Water Eaton (Site PR6a): Consultation Response Tables (27th February 2024) – SUBMISSION VERSION

OUTLINE PLANNING APPLICATION (CDC REF. 23/01233/OUT)
COMPREHENSIVE SUBMISSION OF FURTHER INFORMATION TO CHERWELL DISTRICT COUNCIL
CONSULTATION RESPONSE TABLES

Table 1 sets out Bellway and Christ Church's Response to Cherwell District Council's Letter of 15th August 2023.
 Table 2 sets out Bellway and Christ Church's Response to Consultee Comments Received since 16th August 2023.

Image 4.1 Land Use and Access Parameter Plan – Drawing 32W

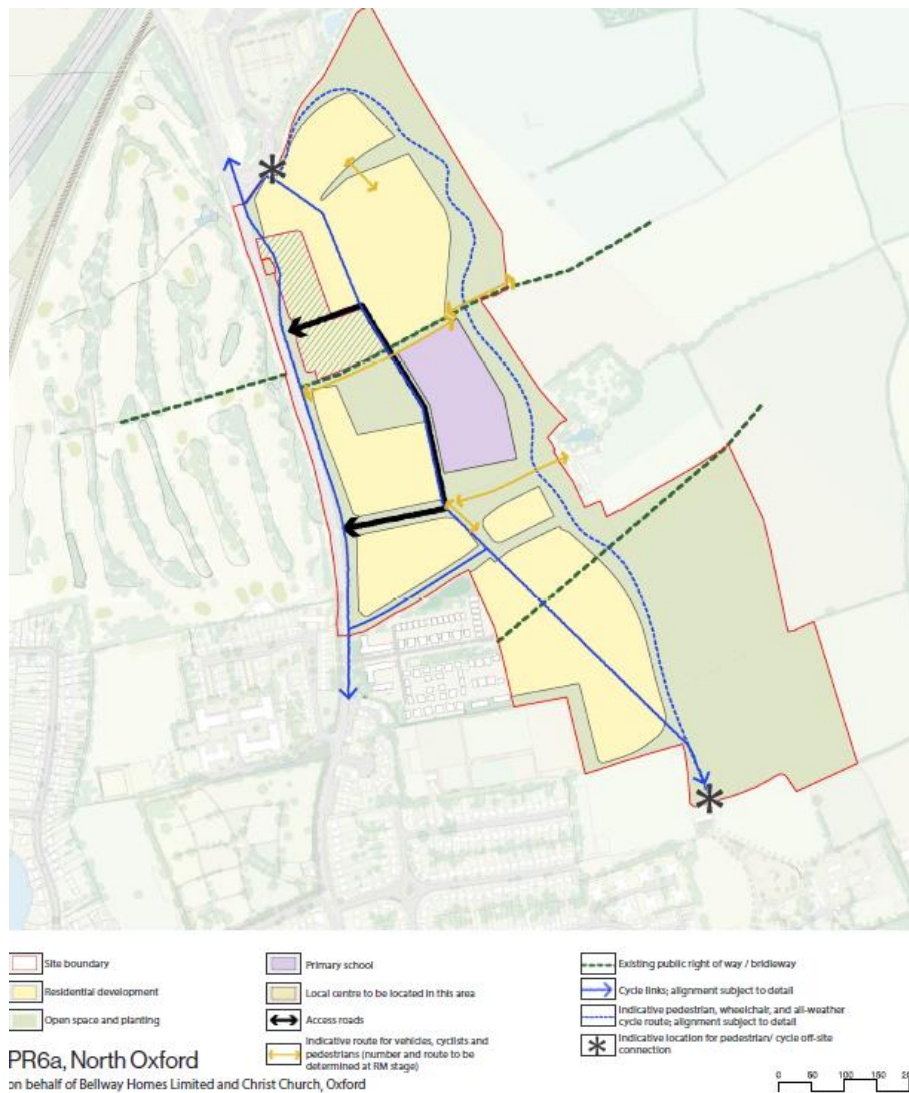
3.2 Land Use and Access Parameter Plan	This is not fully in accordance with the approved development brief of Policy PR6a in terms of the location of the school and local centre which were under much discussion at pre-application. The location of the school and local centre in close proximity to one another is welcomed, however, the proposed school site is compromised by the eastern green infrastructure buffer and the barrows. The issue of whether there is sufficient to accommodate the spine road and the school site between these two constraints remains a potential issue which must be clarified prior to outline consent being issued. It is noted that the plan indicates the school site with a variation of +10/~10 metres along each of the boundaries, with the exception of the eastern boundary. This variation could be critical if the northern and western boundaries were moved outwards by 10m and could result in the school location being considered unacceptable further down the line. The position and indicative layout of the school site was discussed at length during the pre-application and has been agreed in principle by OXCC Education. The comments in their consultation response are relevant in terms of the final delivery of the school and the outline submission must therefore confirm that the school site identified can be successfully delivered in this location without compromising green infrastructure or the barrows.	The reference to these variations has been removed from the Land Use and Access Parameter Plan (477898-32W).

3.2.1	This parameter plan also advises that the access roads are subject to a centre line deviation of +15/~15 metres, this is of concern in respect of the proposed cyclops junction which is now proposed very close to the existing St Frideswide Farm access and existing species rich hedgerow which runs alongside its northern boundary. The removal of this hedge would not be acceptable. Further the position of the main spine road through the site is severely constrained by the proposed school site, green infrastructure to the eastern boundary and the archaeology to its western boundary. These	The reference to these variations has been removed from the Land Use and Access Parameter Plan (477898-32W).

Figure 35 Proposed movement network

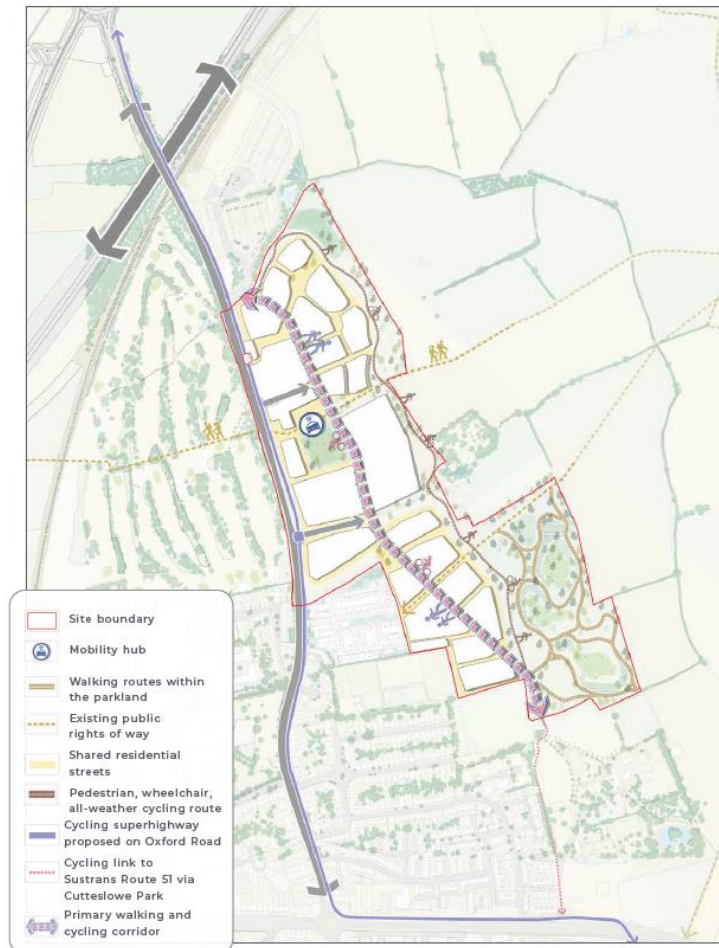
2.14	In terms of the proposed school street, the submission is not consistent in how the site can be accessed by vehicles when the street is closed, for example, the plan on page 94 is not consistent with the street strategy plan or the proposed movement plan. This alternative route will need to be of sufficient width to accommodate this traffic, including deliveries and possible refuse vehicles. This requires consideration and clarification. It also appears to encroach into the green infrastructure alongside the bridleway and the barrows.	Revisions have been made to the Design and Access Statement (WE/DAS/P02). All drawings have now been updated to consistently show agreed school arrangement.

Figure 36 Street Hierarchy Map

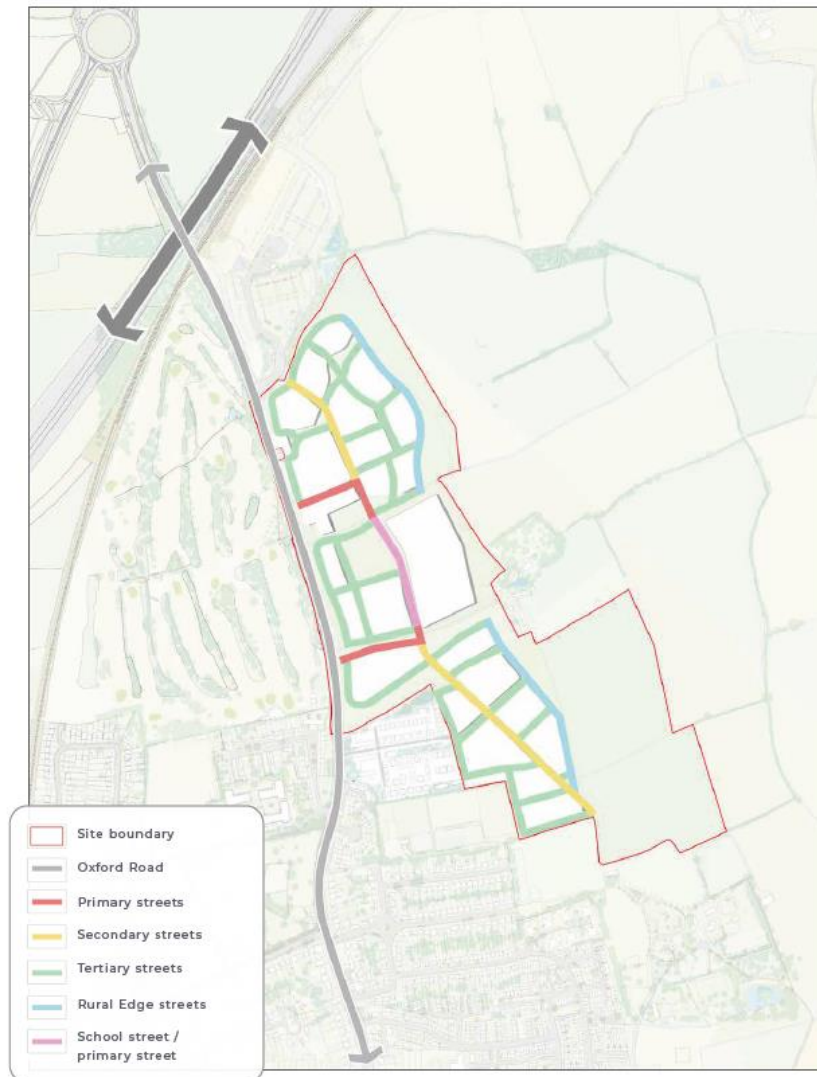
2.10	Page 113 advises that access to Water Eaton and St Frideswide Farm will be through new roads provided within the development, however, the plan on page 106, Fig 36 shows these as tertiary	Revisions have been made to the Design and Access Statement (WE/DAS/P02) (Page 113 (para 6.2.7, 6th bullet point)).

2.11	The rural streets are described as private drives. The use of private drives precludes connectivity and will therefore not be appropriate along this green edge with the landscape buffer. Access into this space will be required from the adjacent development parcels.	The proposed Rural Edge Streets are not proposed to be private and their design and scale, including planting, will enable an appropriate transition between the housing along Tertiary Streets and the wider countryside. Connectivity between the adjoining Tertiary Streets and Rural Edge Streets (as shown on Figure 36) has been the subject of consultation with OXCC Highways (Pages 105-106 and 111).
